From: Gregg, Robert <Robert.Gregg@lancashire.gov.uk>
Sent: 06 March 2019 12:20
To: Stephen Kilmartin
Cc: planning; LHS Customer Service
Subject: APP. 3/2019/0069 - 63 LITTLEMOOR ROAD, CLITHEROE

Single storey rear extension and conversion of western end of garage to create utility.

PROPOSED PLANS

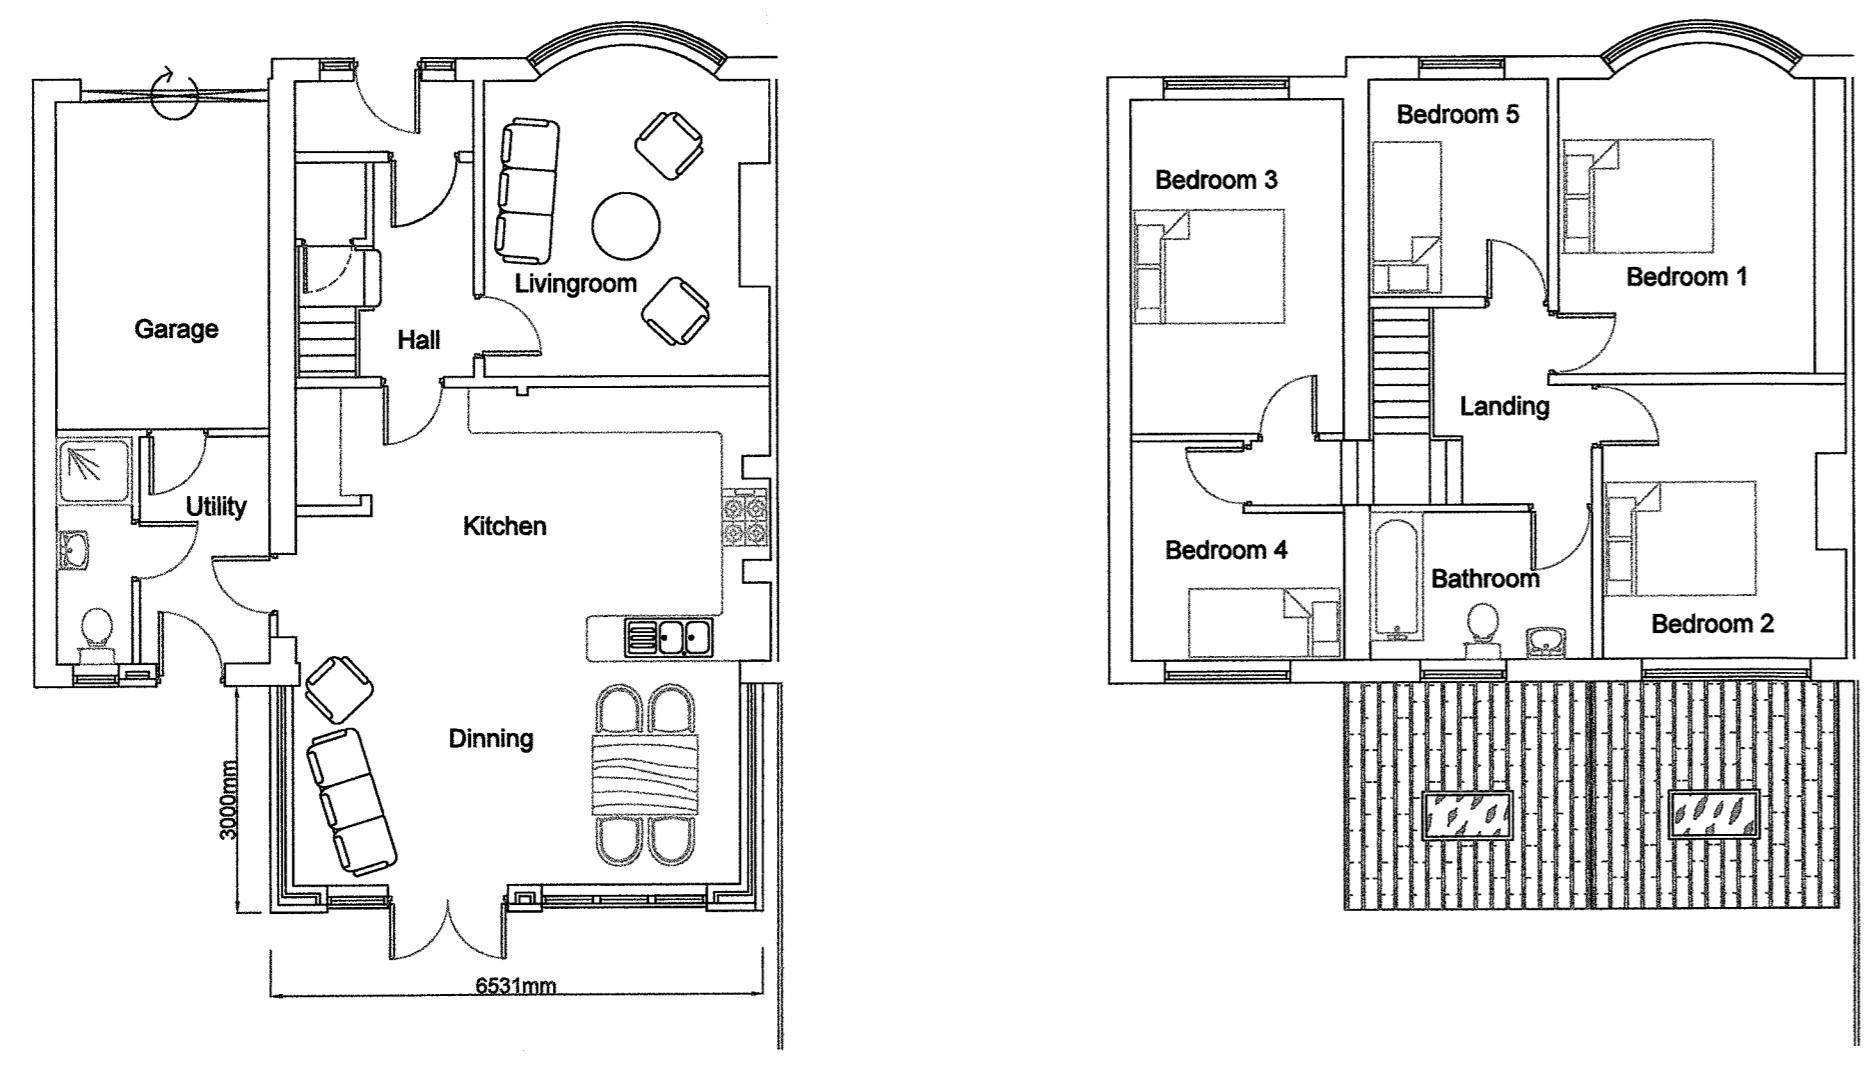
With respect to the above application, in accordance with your correspondence dated 26 February and 04 March. It has been confirmed that the removal of the proposed utility area from the proposed plans will not be submitted in a revised layout. However you have ensured and confirmed that the utility area will not be incorporated in to the proposed development and as such I would raise no objection on highways grounds.
